## **SOILS AND GEOLOGY STUDY**

**Windermere Subdivision  
El Paso County, Colorado**

**JOB NO. 162062**

**October 26, 2020**

PP02

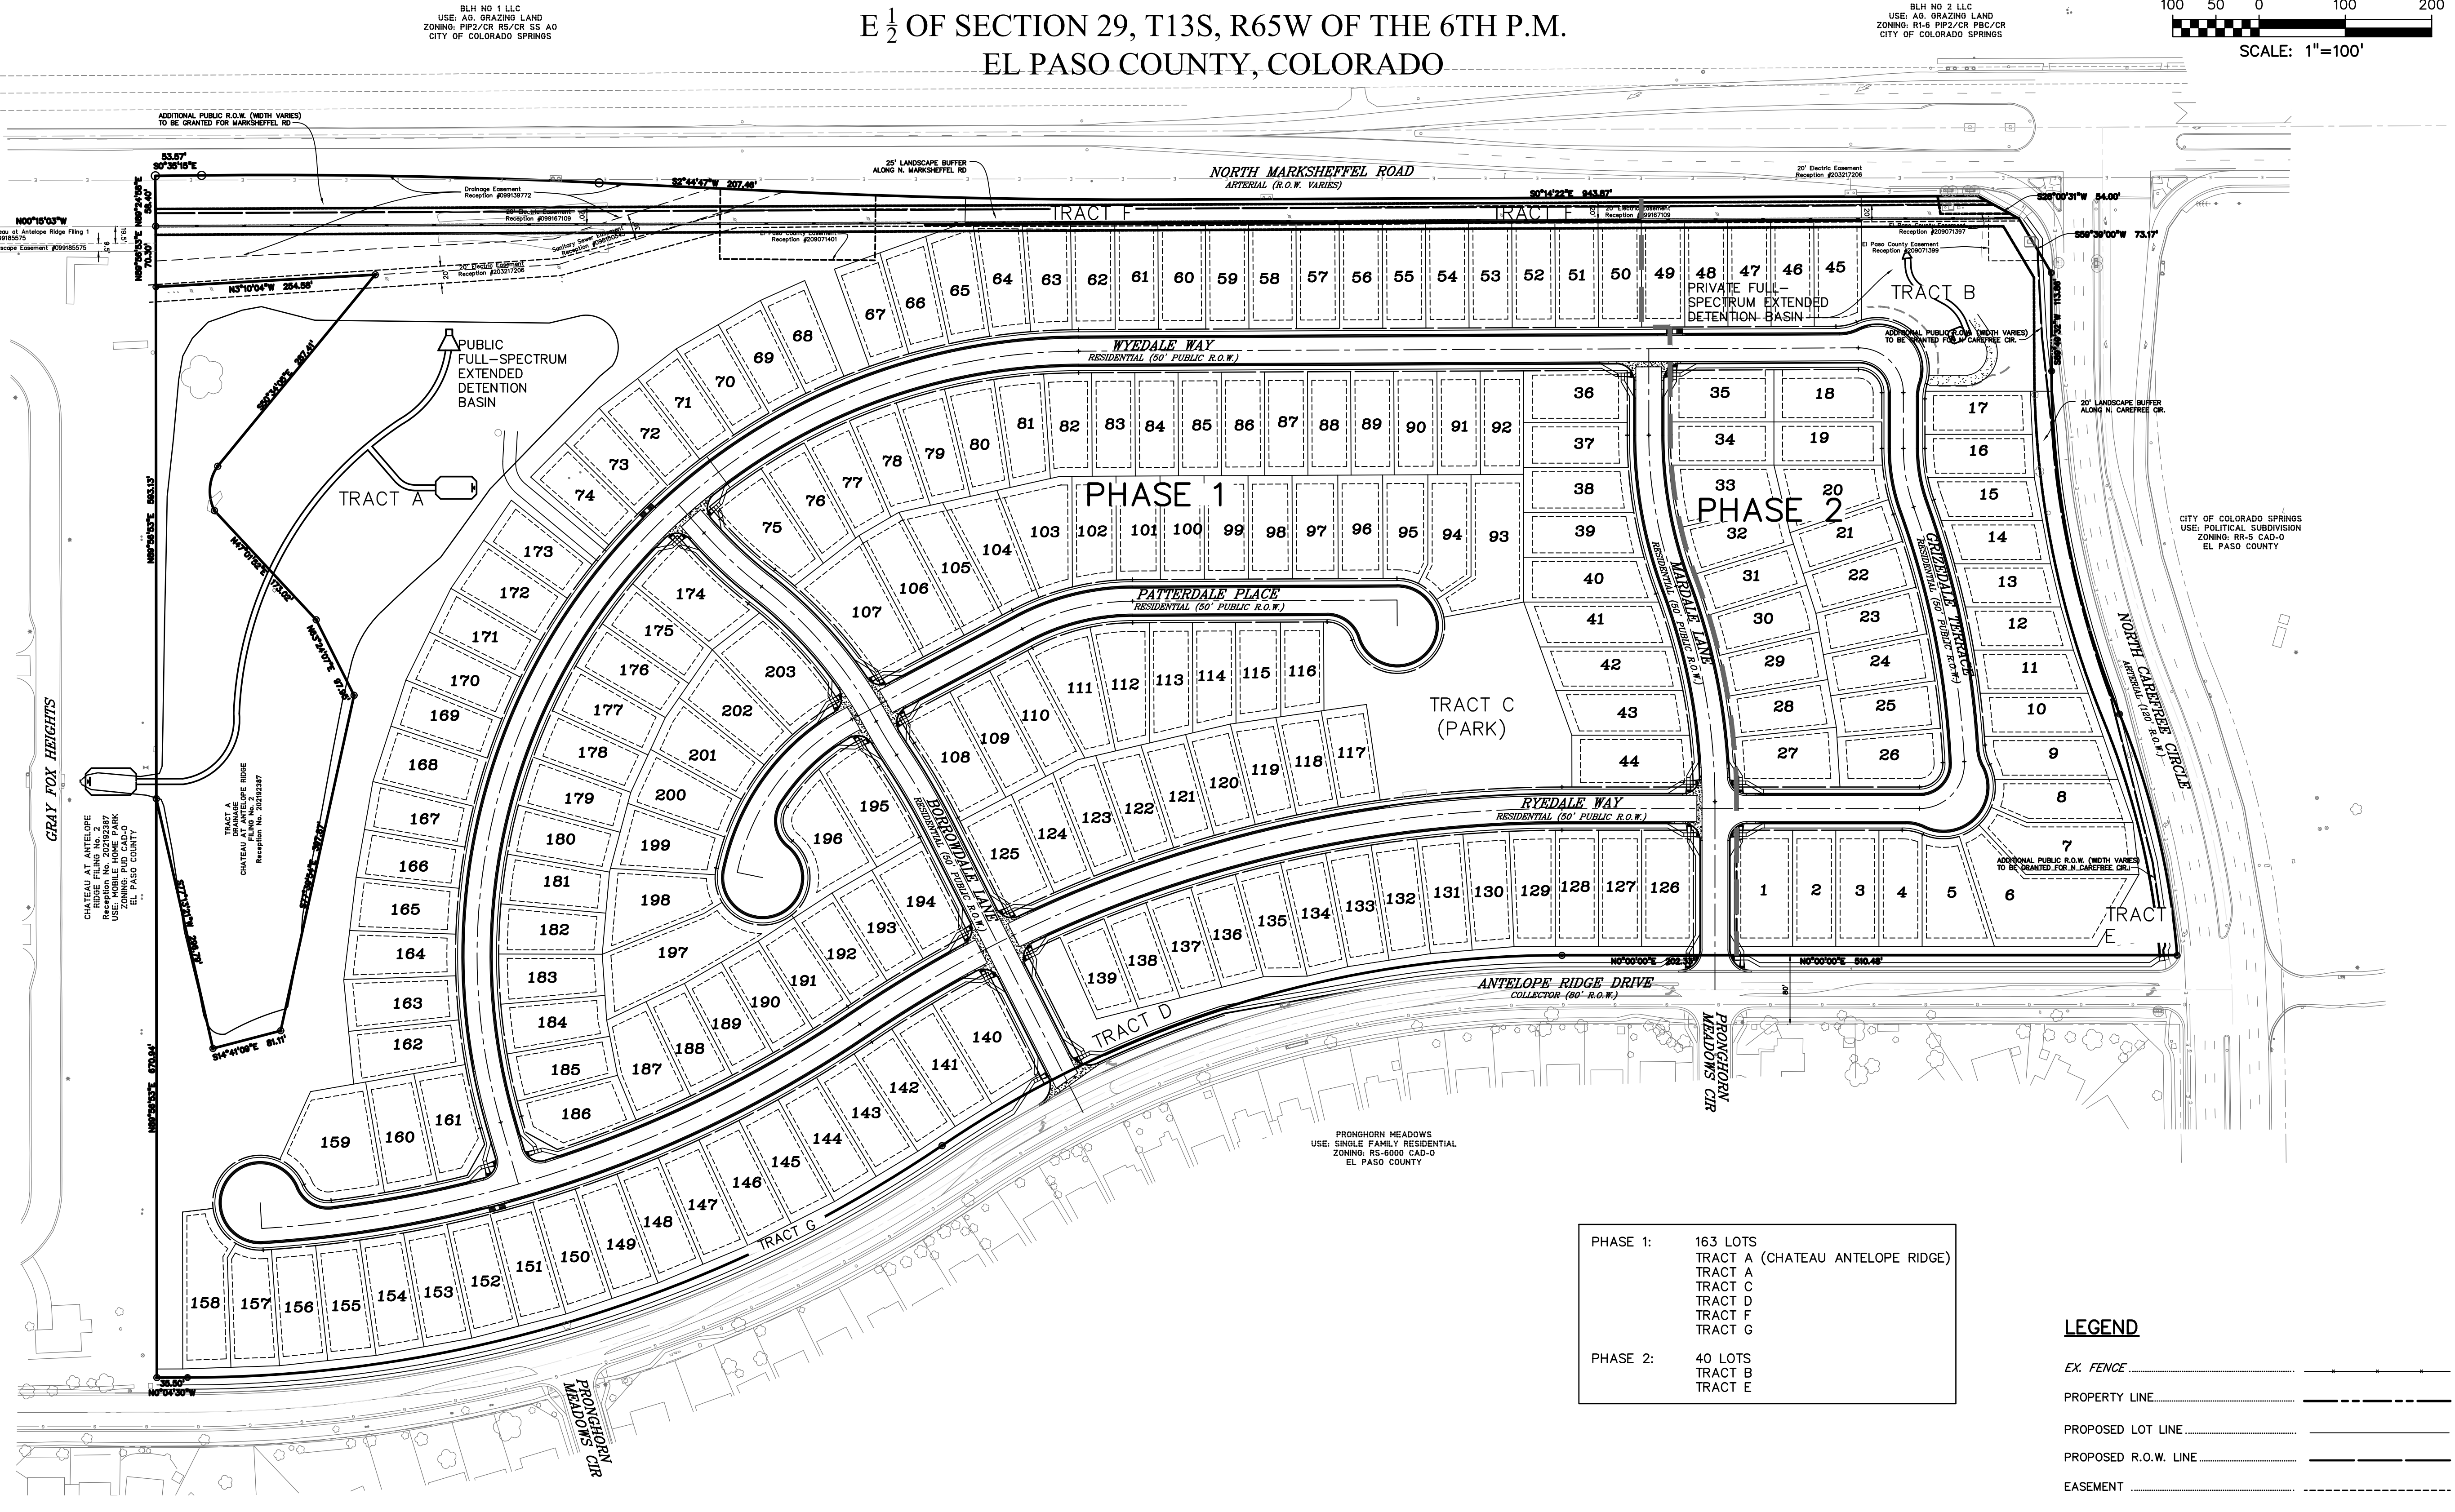
Please incorporate  
CGS comments into  
report, and provide  
notes on prelim plan  
regarding  
basements, and  
underrais...

This should be mapped in a figure and then reflected on prelim plan...
